**KIRKLEES METROPOLITAN COUNCIL
INVESTMENT & REGENERATION SERVICE**

**DELEGATED DECISION TO DETERMINE APPLICATIONS FOR LISTED
BUILDING CONSENT**

Reference No: 2021/65/91672/W

Description: Listed Building Consent for Installation of ATM

PROPOSED ELEVATION

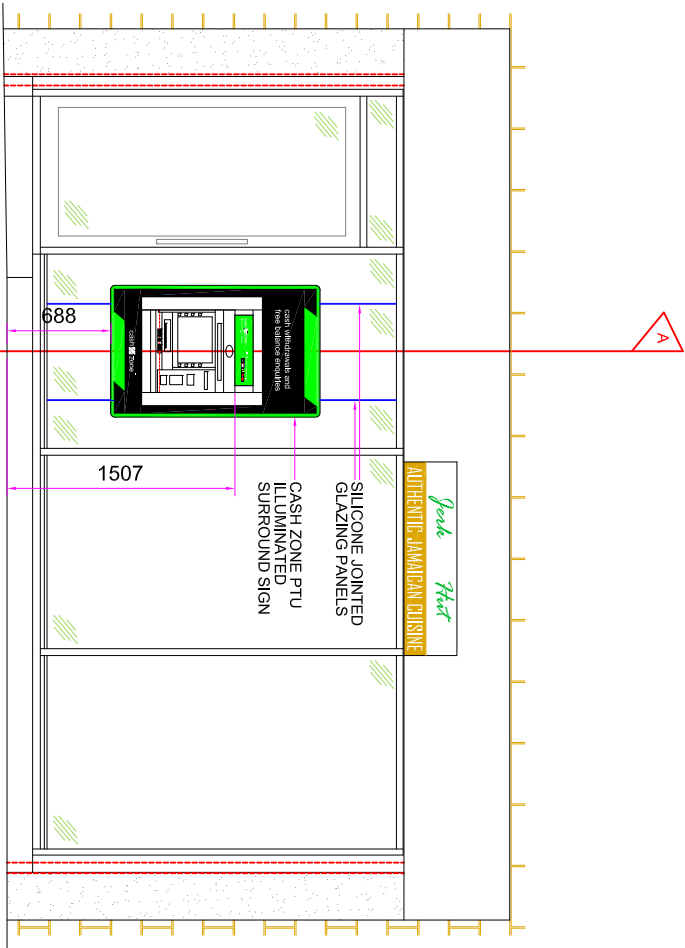
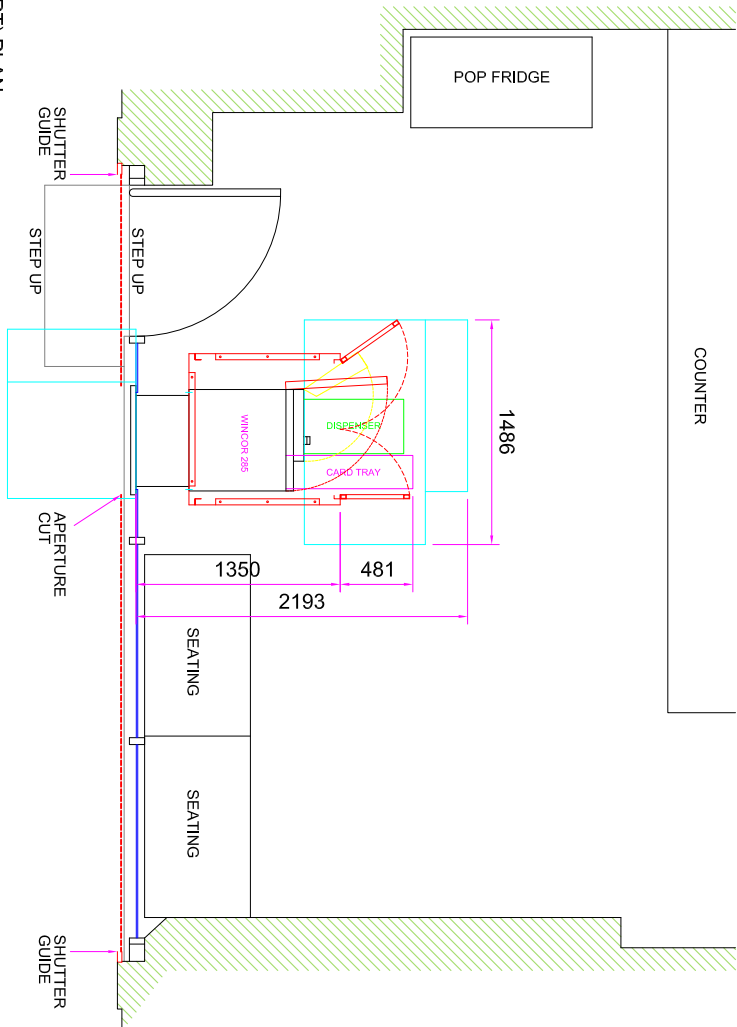
The application is seeking Listed Building Consent for the installation of a ATM. This would be installed to the right of the pedestrian door within the glazed frontage.

In this instance the ATM is proposed to be installed within the shop's glazed frontage. However, it has been noted that the aluminium framed shop front itself, does not have formal planning permission or listed building consent. Although it would appear this has been in place for more than 4 years, the carrying out of work without the necessary listed building consent, whereby such works materially affect the historic or architectural significance of the building, is an offence under section 9 of that Act – whether or not an enforcement notice has first been issued.

The ATM would further harm the significance of the building, viewing this in its own right as well as- outside the scope of this application - taking into account the unauthorised modern design of the shop front, roller shutters (and replacement windows which do not have listed building consent either). This has raised significant concerns from KC Conservation and Design Officers, as they consider the works to cause harm to the character and significance of the Listed Building, contrary to Paragraph 196 of the NPPF.

Heritage officers have also outlined that the installation of the ATM, with an internally illuminated surround would cause further harm, by introducing an additional modern element in a prominent location of the building.

1. The proposed ATM, by introducing an additional modern element in a prominent location of the building, would not preserve or enhance the building's special architectural and historic interest and would cause harm to its significance. The harm caused is considered to be less than substantial harm, however, as required by paragraph 193 of the NPPF, great weight has been given to that harm in assessing the impact of the proposed works. Clear and convincing justification has not been provided for the harm caused. Public benefits have not been demonstrated that would outweigh the harm caused in this case. The development would therefore be contrary to the Council's duties under Section 16(2) of the Planning (Listed Buildings and Conservation Areas) Act 1990, Policy LP35 of the Kirklees Local Plan and Paragraphs 190, 193, 194 and 196 of National Planning Policy Framework.
